From: Martyn White **On Behalf Of** Conservation Officer
Sent: 30 November 2018 09:48
To: Planning.Responses
Cc: Anita Gardner
Subject: AB/104/18/L

AB/104/18/L

Scale 1 : 50 & 1 : 100 April 2018 No. 83/18/01

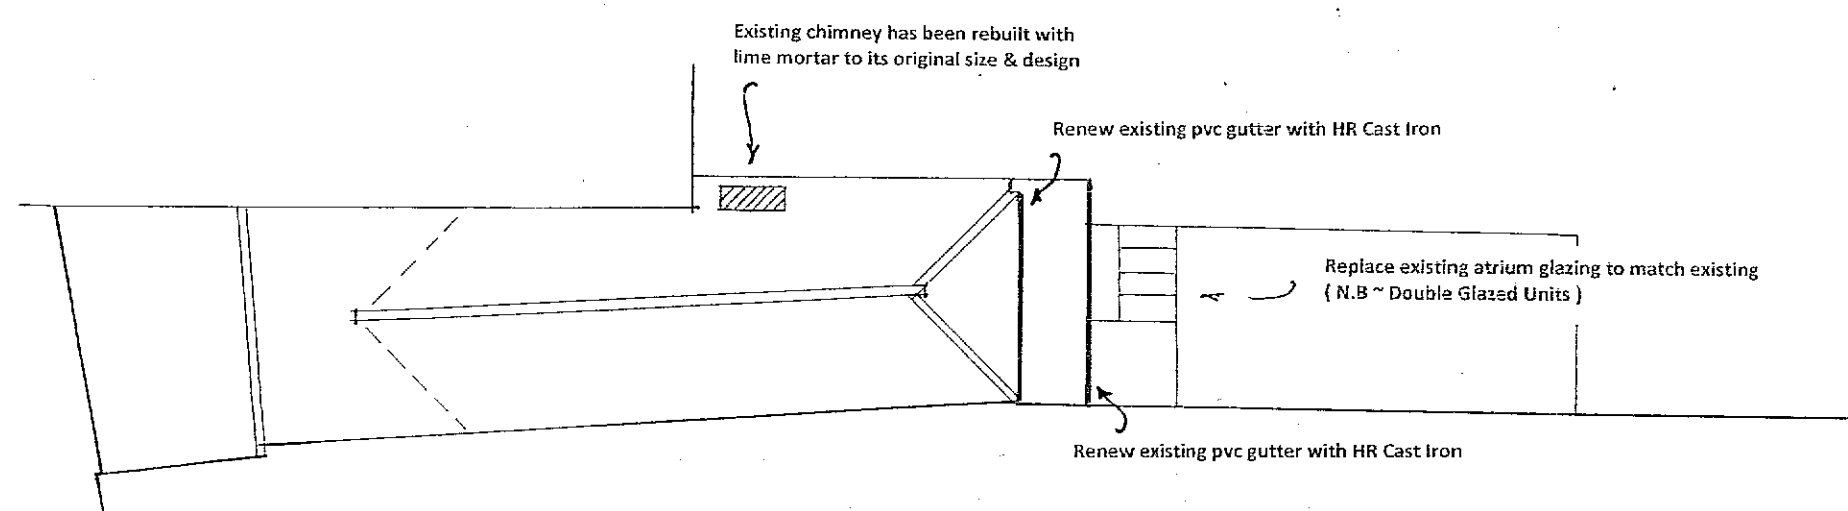
The works to the chimney have already been undertaken, on a like-for-like basis, using traditional materials (lime) and it is considered that the works are therefore acceptable in this instance.

The replacement of the UPVC guttering with cast iron is supported as it will enhance the appearance of the building, and introduce traditional materials. It is assumed that it will be painted black. The renewal of lead gutter at low level is supported as long as it can be confirmed to match existing.

However, I also note that reference is to other works on the existing elevations: namely the retention of the existing air conditioning unit, and the replacement of the existing atrium glazing with double glazed units. Are such works included within this application? If so, the description needs to be amended to reflect these proposed works. Further, I will then need to provide comments on those areas of development.
